RFI

RFI #: 179
Date: 8/7/2012
Job: EB-02 Keller Springs Lofts
Phone: 877-777-5115

Subject: Hollow metal door at 7th level of stair tower #4

Drawing: 1/6.4, 1/3.7D
Cost Impact: None

SHEET NUMBER  
**3.7D**  
BLDG PLAN 'D'

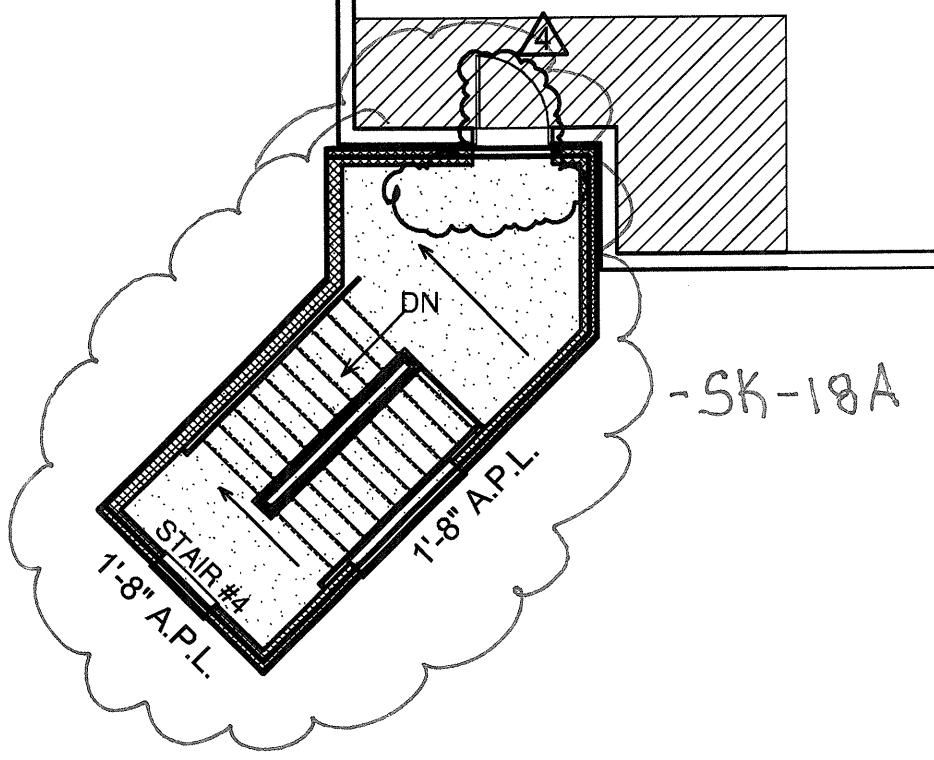
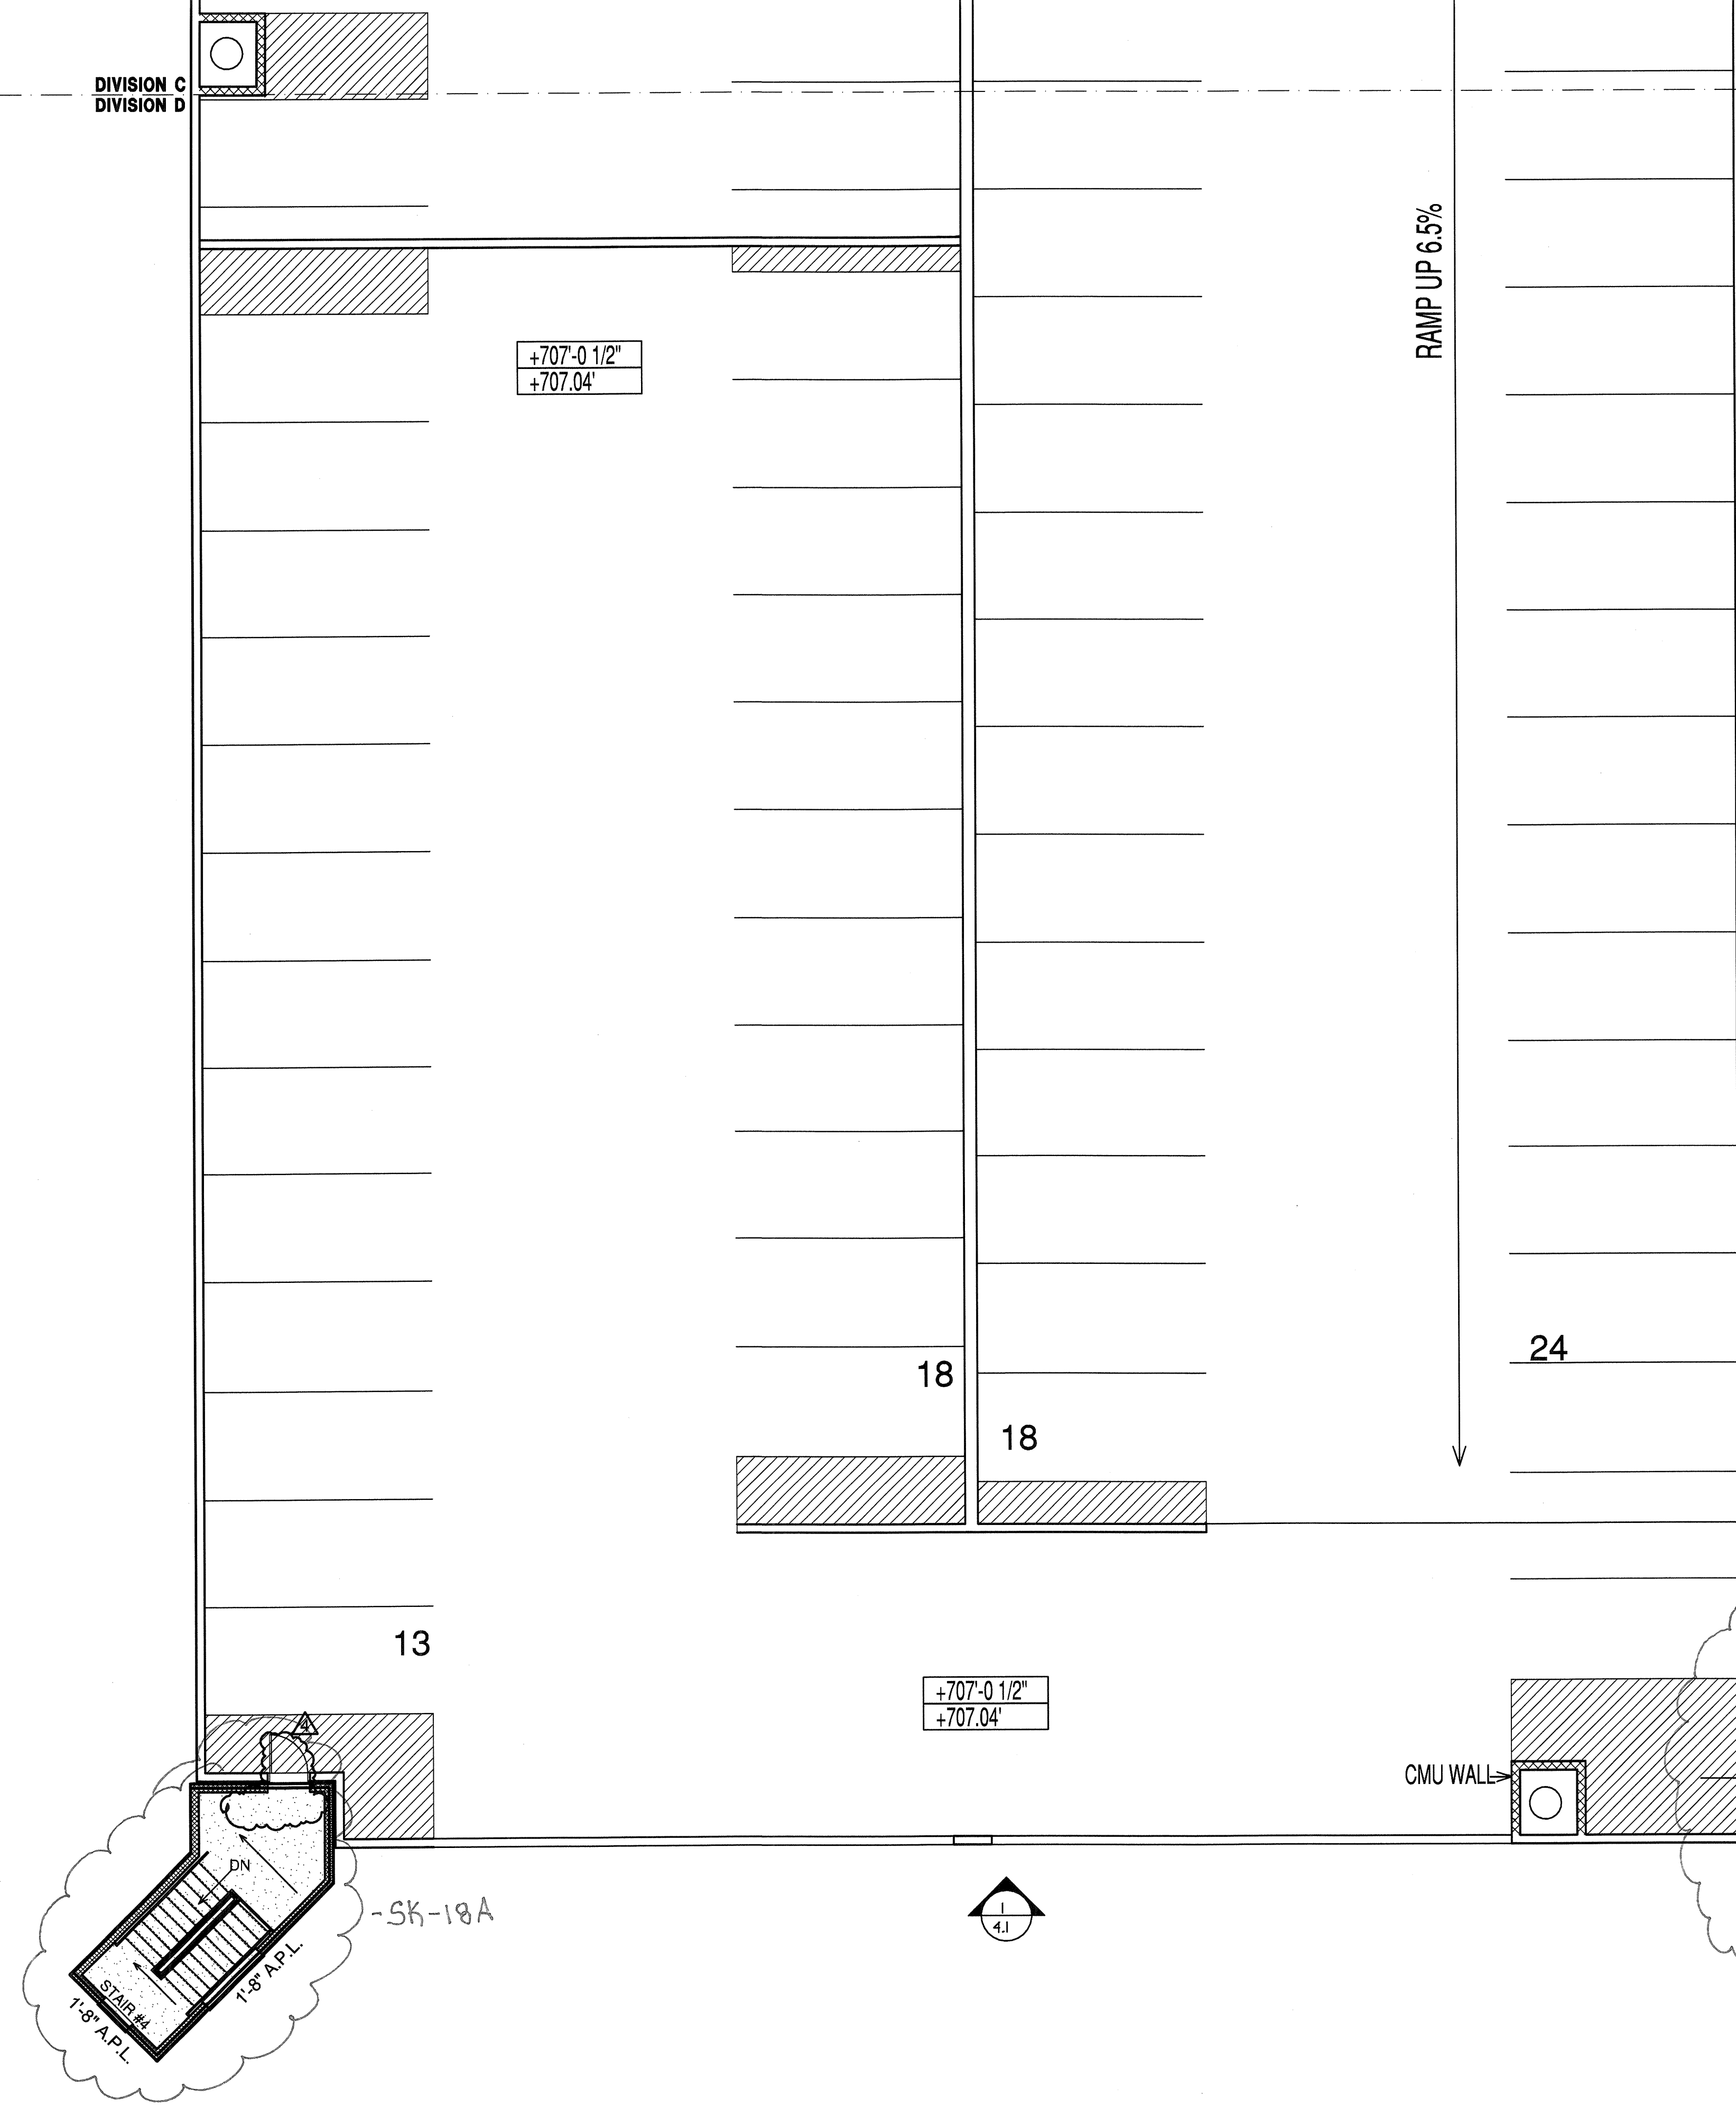
Request: The hollow metal door on the 7th level of stair tower #4 shows being mounted into the garage pre-cast wall, on the 7th level of the garage the pre-cast wall stops 42" above finish floor of the garage. Therefore, the door will have to be moved into the stair tower CMU wall. Since the door is a left hand swing I purpose we use the same door and swing it into the stair tower similar to stair tower #5 and solve this issue. Please advised and respond ASAP as we are up to the 4th level now with the CMU. **Date Required: 8/8/2012**

Response:
what you propose for the 7th floor door in stair tower #4 is acceptable.
